From: Anita Gardner
Sent: 25 June 2019 10:46
To: Lynnyrd Wolfe
Subject: FW: F/30/18/PL - Drainage comments
Attachments: Ag Invest - Wicks Farm - ADC - Polytunnels - Reservoir - Drainage - 8th May 2019.pdf

Subject: RE: F/30/18/PL - Drainage comments

Thank you for your comments concerning our application to erect multispan polythene tunnels at Wicks Farm, Ford – F/30/18/PL.

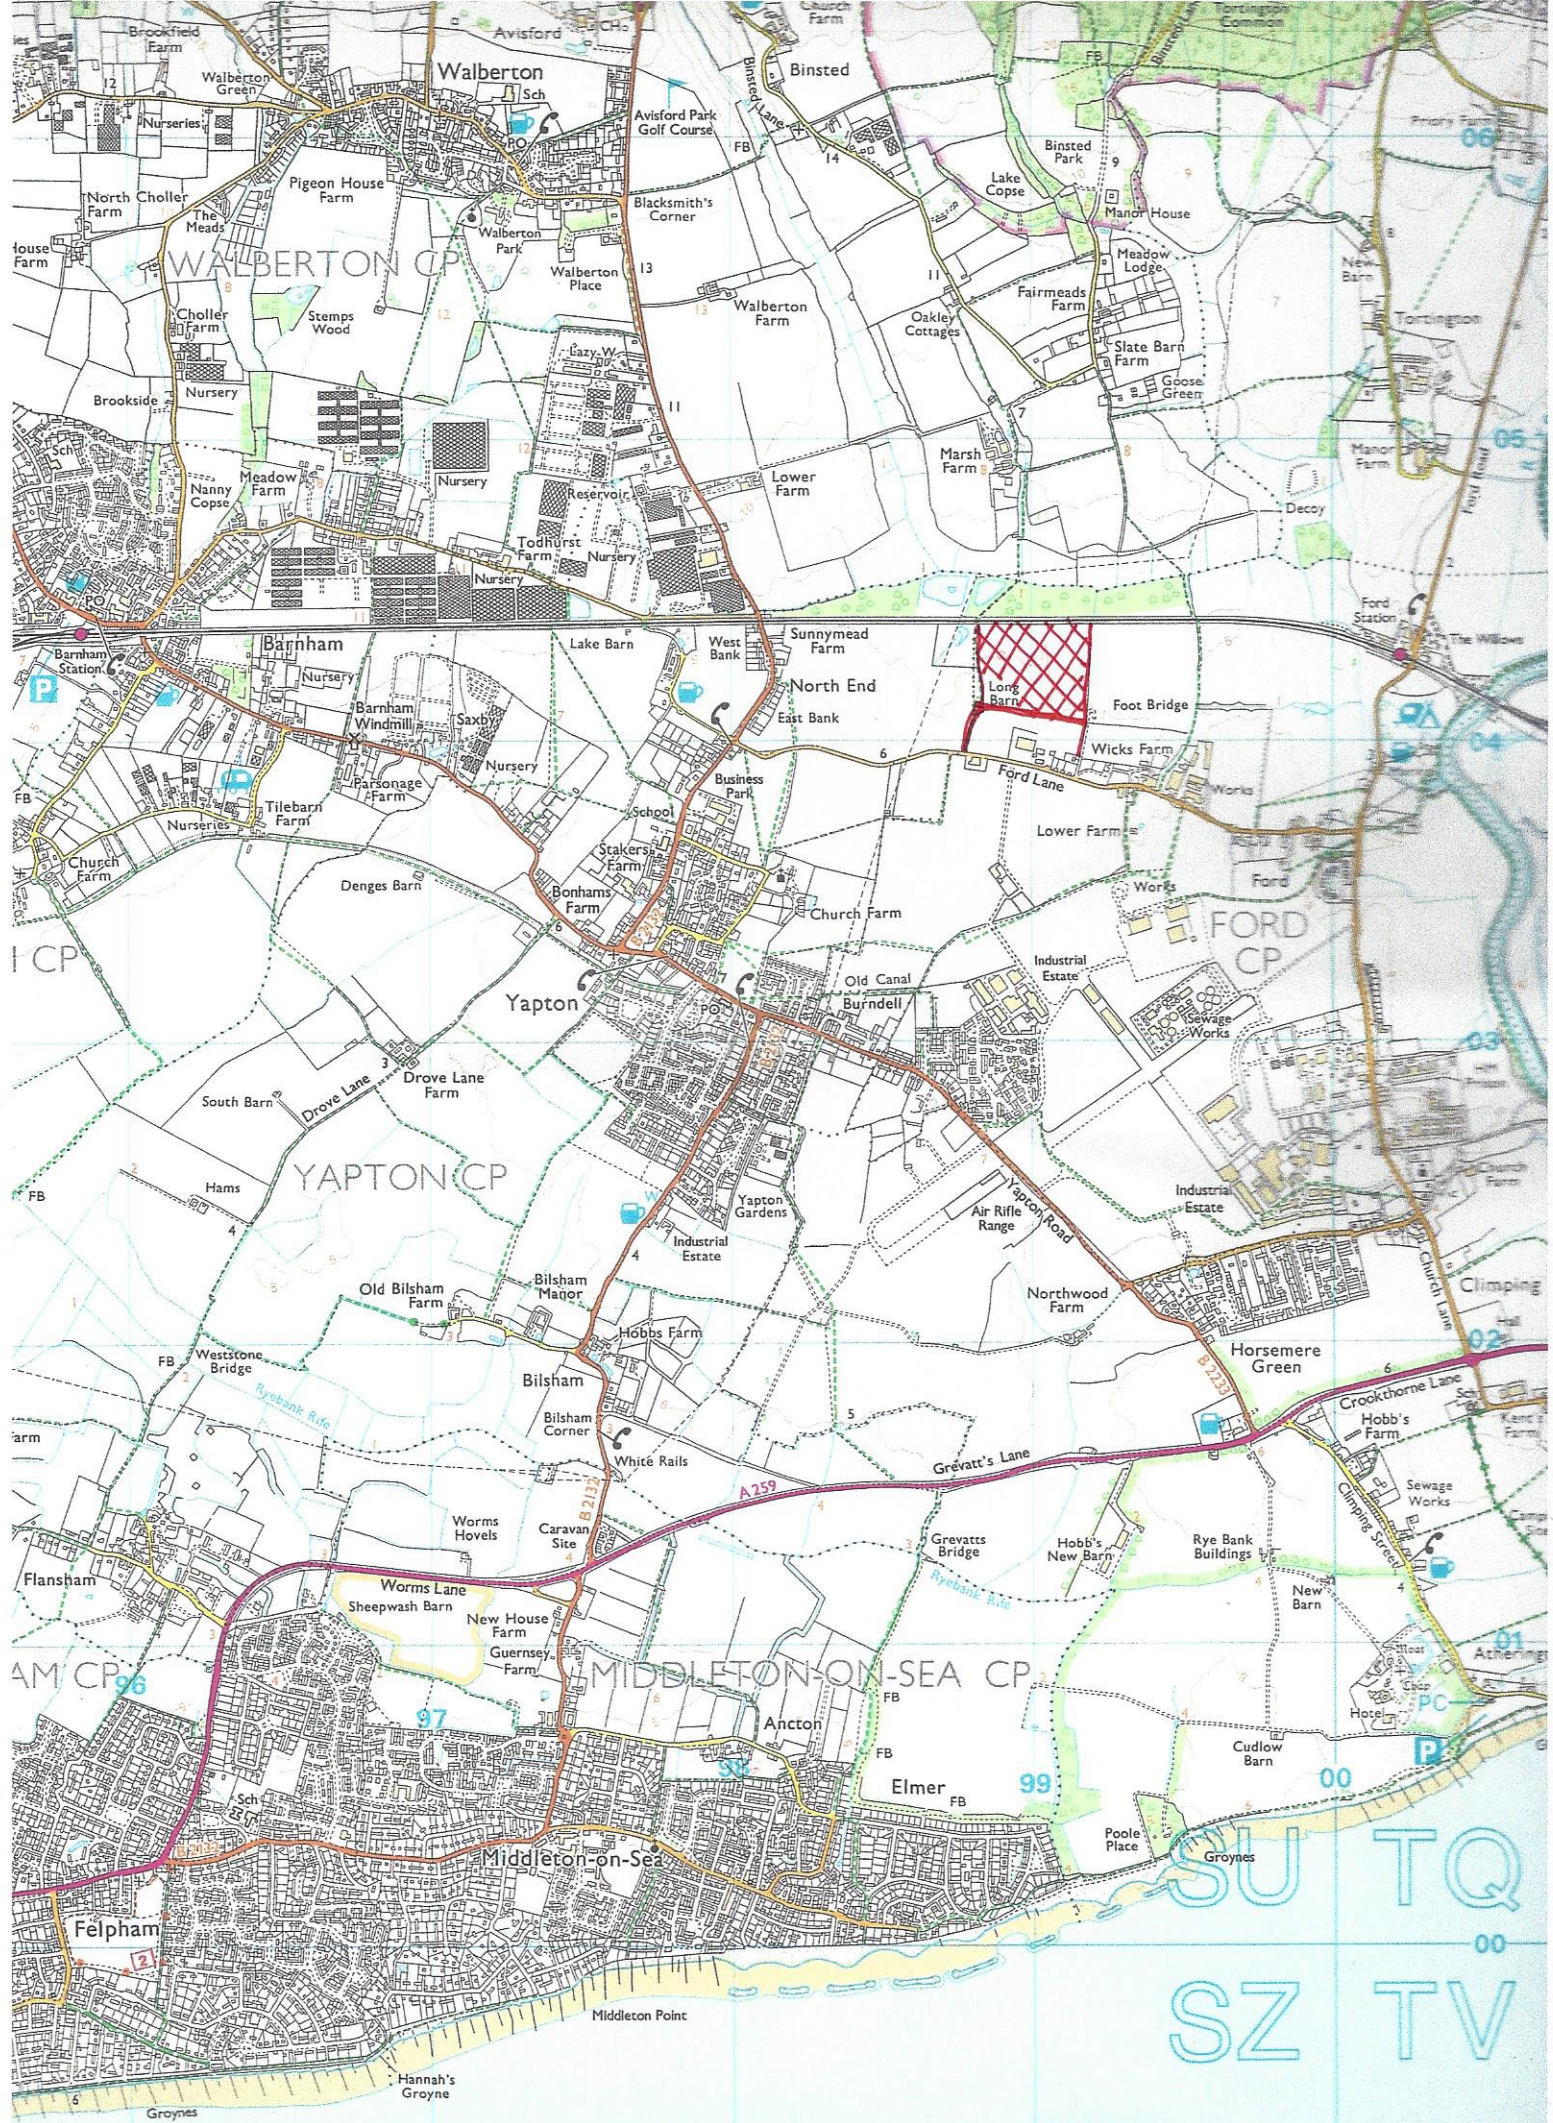
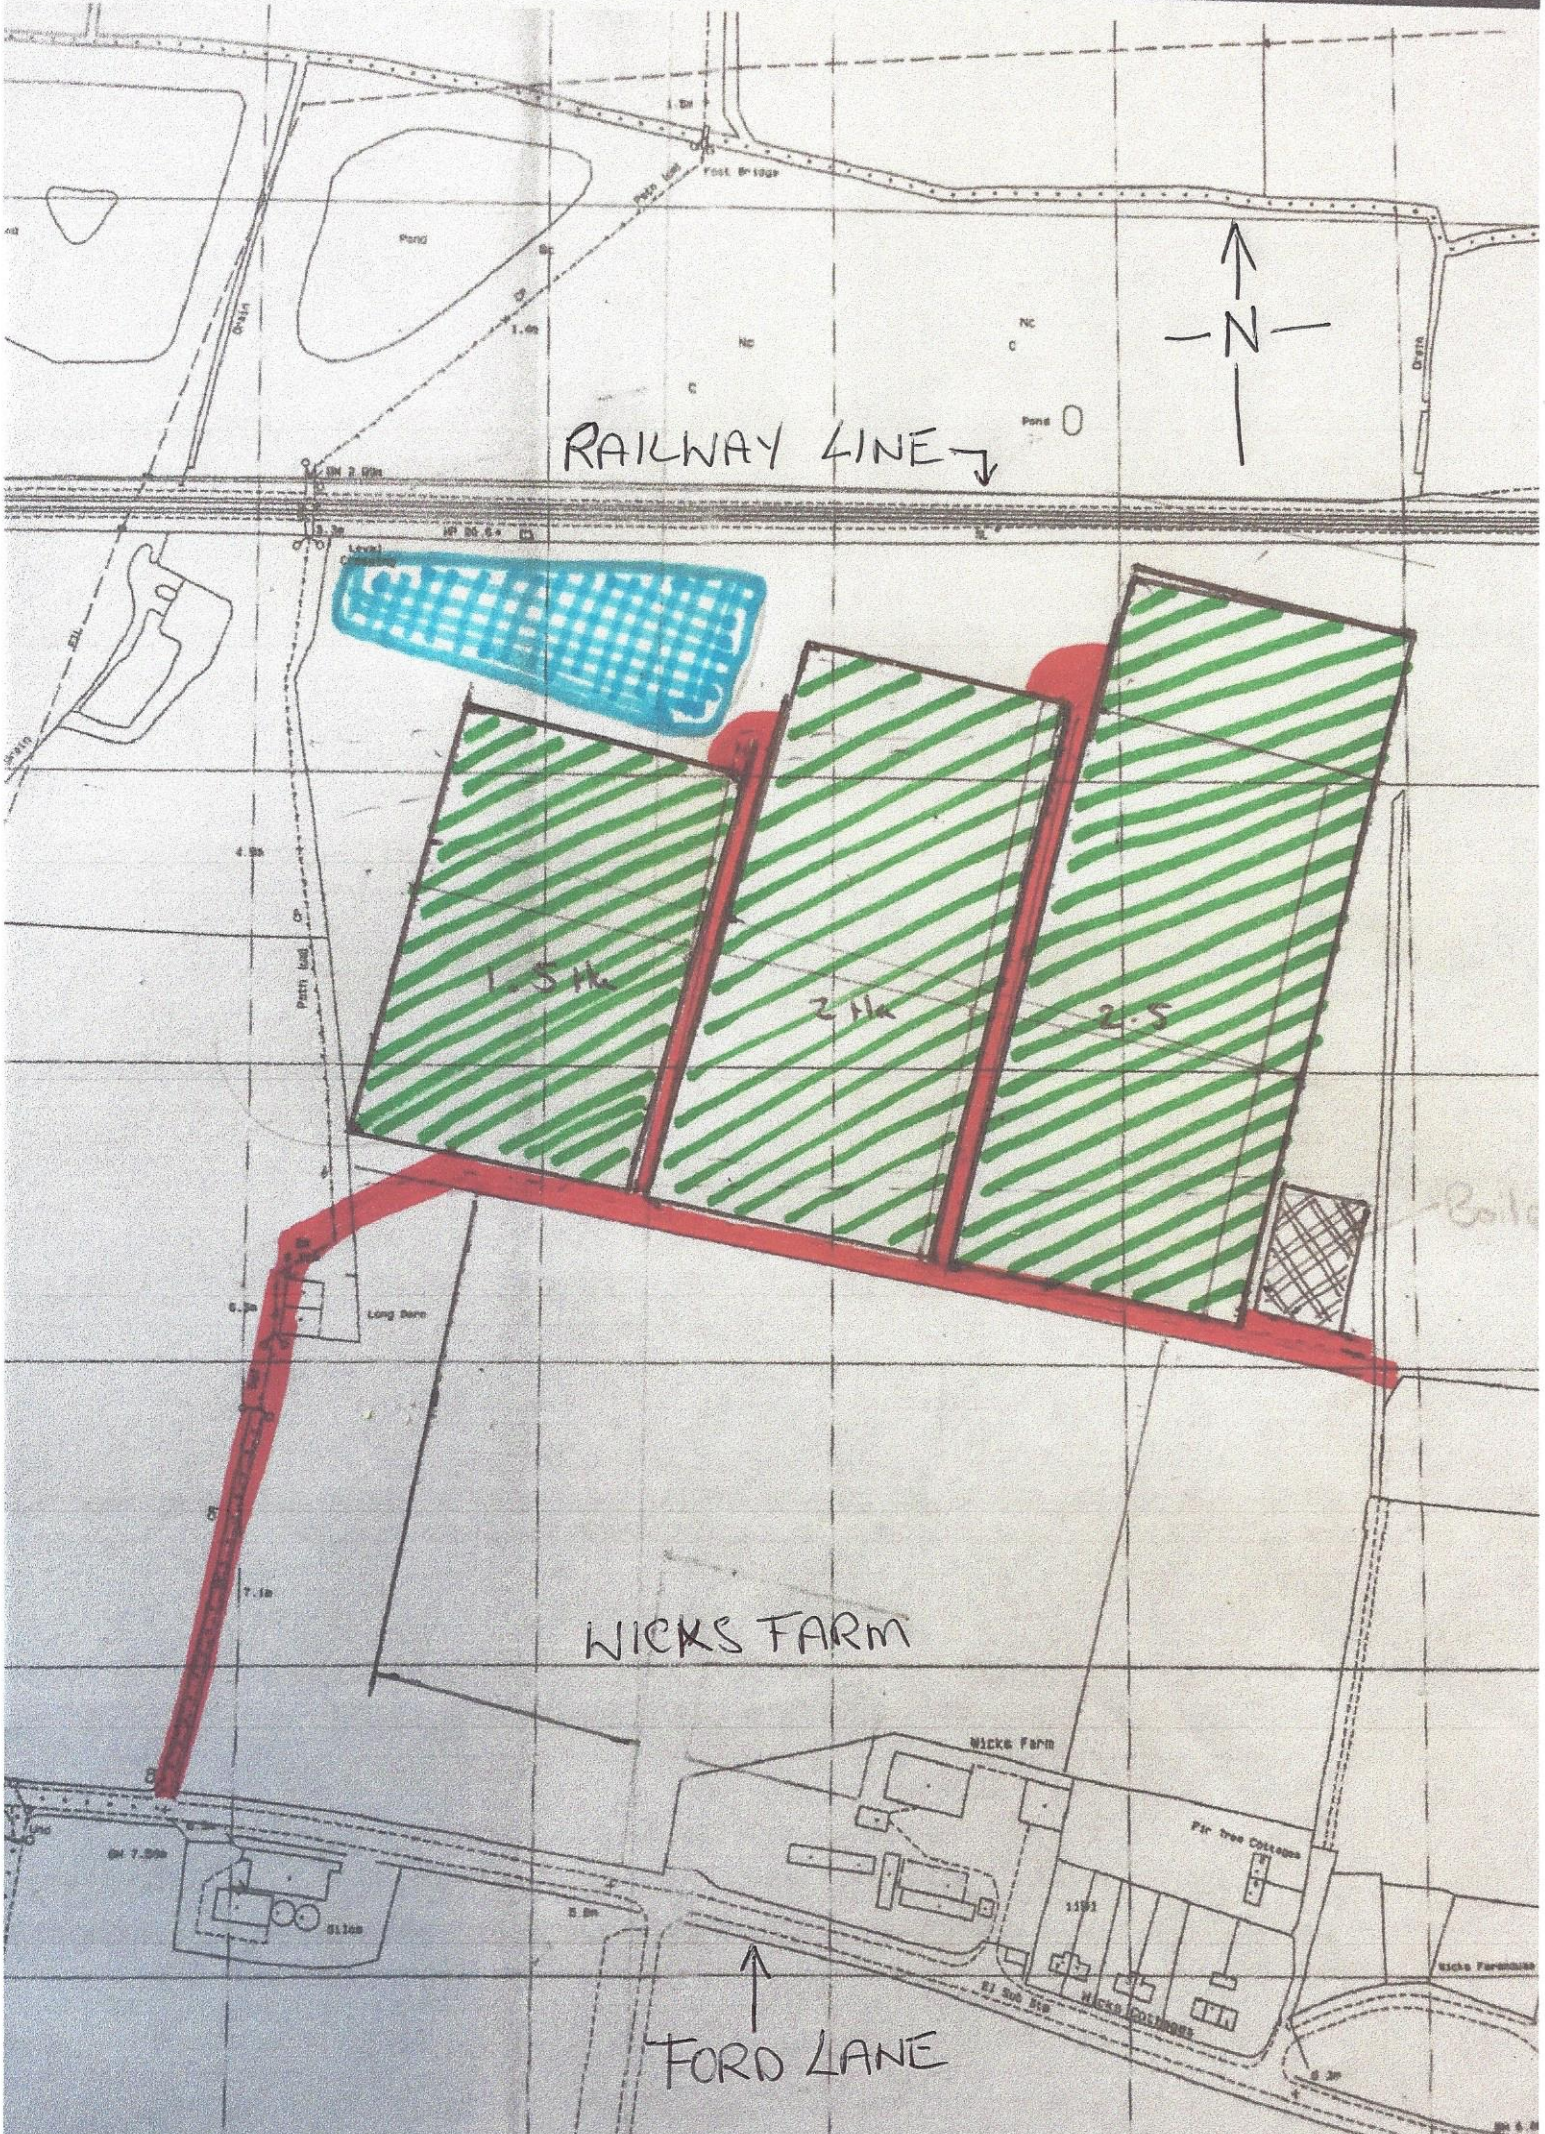
My main concern is the location of this proposed overflow. I.e. which watercourse are you discharging to and where? Without this information the fundamental concepts cannot be agreed.

Can you please update the surface water drainage proposals to clearly show this proposed overflow to the ditch system?

Please find attached a copy of the marked OS Plan showing the drainage ditches from the reservoir to the River Arun.

The overflow from the proposed reservoir at Wicks Farm will discharge into the ditch that runs along the Northern boundary of the field. This ditch joins the major drainage channel at Ford before passing under the Ford Road and then directly into the River Arun.
